# Charlotte Department of Transportation

## Memorandum

**Subject:** Rezoning Petition 08-056: Located on the southwest corner of Nations Ford Road and West Tyvola Road (revised 2/25/08)

DATE: MAY 19, 2008  
 DRAWN BY: M. HUGH  
 CHECKED BY: M. HUGH  
 Q.C. BY: AP  
 SCALE: 1" = 60'-0"  
 PROJECT #: 018501  
 SHEET #: C.1.0

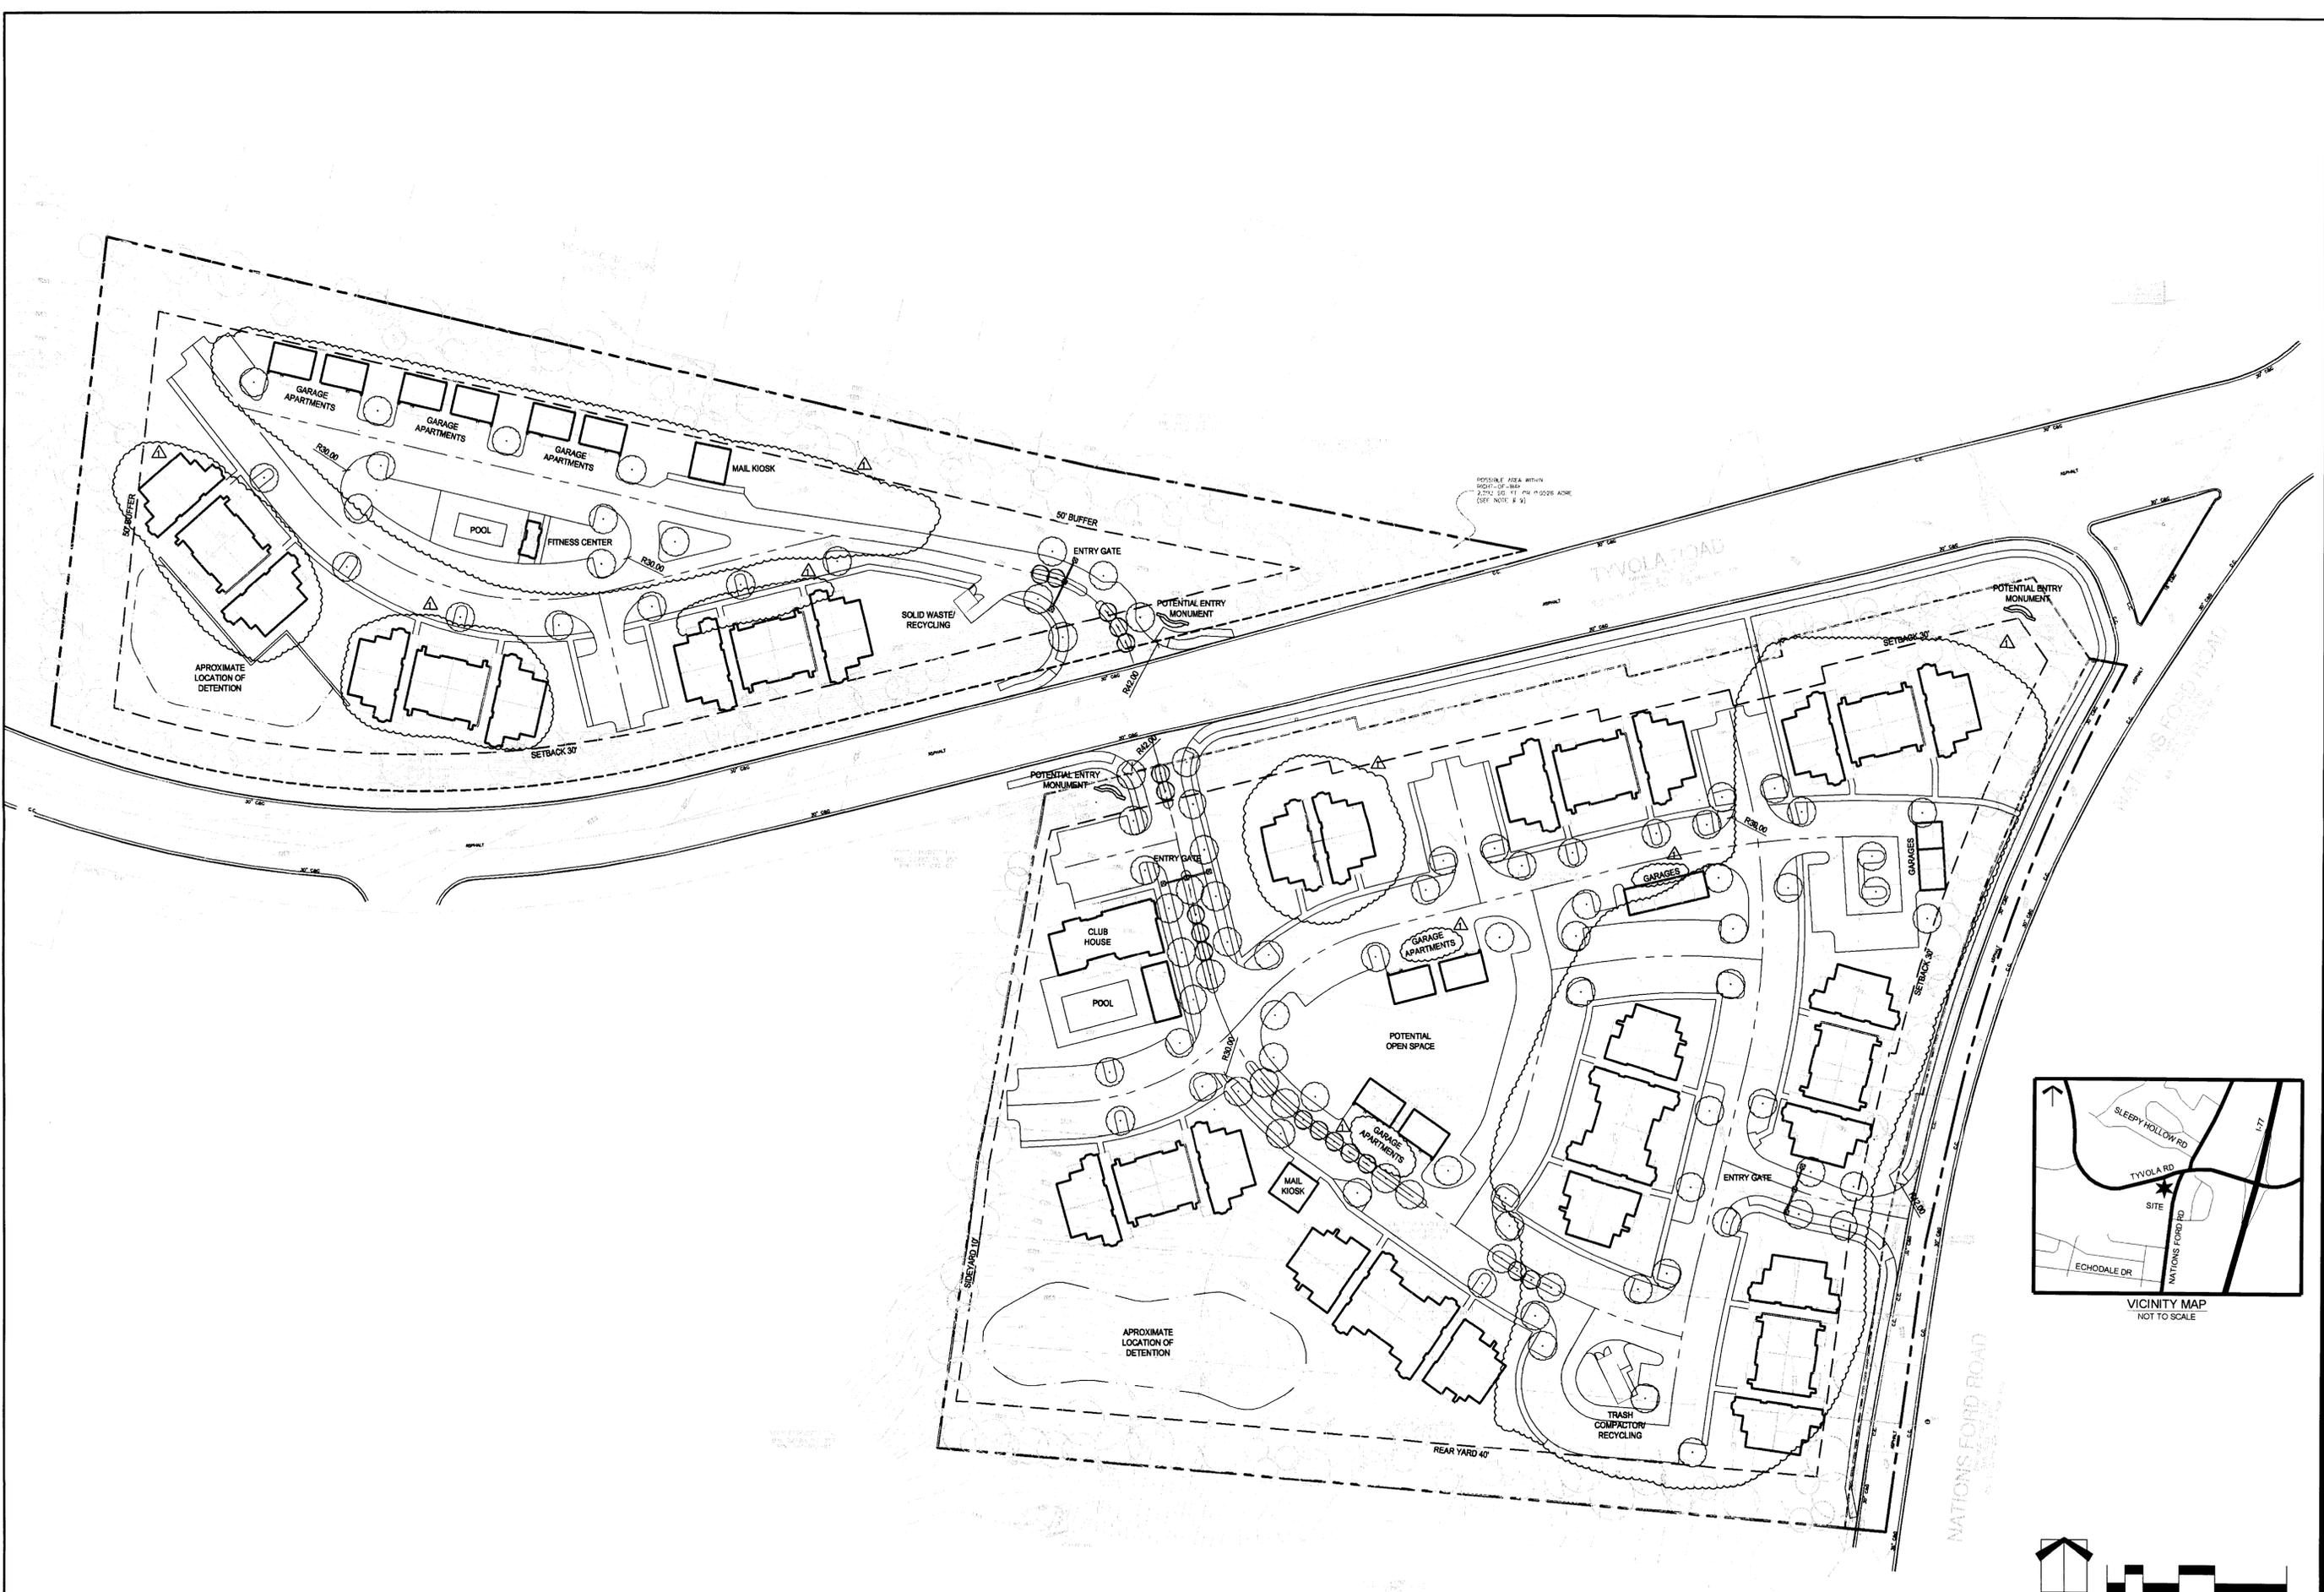
1. Left-turns into the proposed driveways cannot be made safely due to the left-turn offset/conflicts. For this reason, CDOT has determined that left-turn lanes on West Tyvola Road (both eastbound and westbound directions) and Nations Ford Road are necessary to serve the traffic using the proposed private driveway connections for this site. Full access/left-turn lanes at the Tyvola Road driveway is conditioned on comment 3 below. On West Tyvola Road it appears that the left-turn lanes may be able to be provided by restriping the existing painted out median area. The engineering design and construction of the left-turn lanes are the responsibility of the owner and shall be performed by a professional engineer registered in the State of North Carolina who has roadway design experience. The design of left-turn lanes need to comply with NCDOT design guidelines with a minimum of 150 feet of storage and will be reviewed during subsequent permitting processes. *(Previous comment)*

If the left turn lanes cannot be constructed to meet minimum standards or the storage length as identified in the traffic study, whichever is greater, and to not impact the existing/adjacent left turn lanes, then access to the site will be restricted to right-in/right-out. This would require the petitioner to construct a concrete median to physically restrict access.

2. The site plan needs to show 6-foot sidewalks and 8-foot planting strips along both West Tyvola and Nations Ford Roads, as measured from any future curb line. CDOT will determine the location of any proposed curblines during the building/driveway permit process. *(Previous comment)*
3. A full-movement access is proposed on West Tyvola Road. CDOT will evaluate this access after review of the TIS. Full-movement may not be feasible at the proposed location.
4. Stubs from the multifamily component to the adjacent multifamily parcels to the west and south need to be provided for site inter-connectivity. A stub needs to be provided to the residential property to the west of the proposed northern multifamily site.
5. Additional comments and any required transportation improvements will follow our review of the TIS. *(Previous comment)*

1. This site plan does not adequately integrate transportation and land use. As currently proposed, the development is too auto-oriented with buildings oriented away from any street and a layout discouraging walking, cycling and transit. *(Previous comment)*

2. An internal system of 5' sidewalks connecting the buildings/uses both within the site and from the building entrances to sidewalks along West Tyvola Road and Nations Ford Road is needed. *(Previous comment)*

Adequate sight triangles must be reserved at the existing/proposed street entrance(s). Two 35' x 35' sight triangles are required for the entrance(s) to meet requirements. All proposed trees, berms, walls, fences, and/or identification signs must not interfere with sight distance at the entrance(s). Such items should be identified on the site plan.
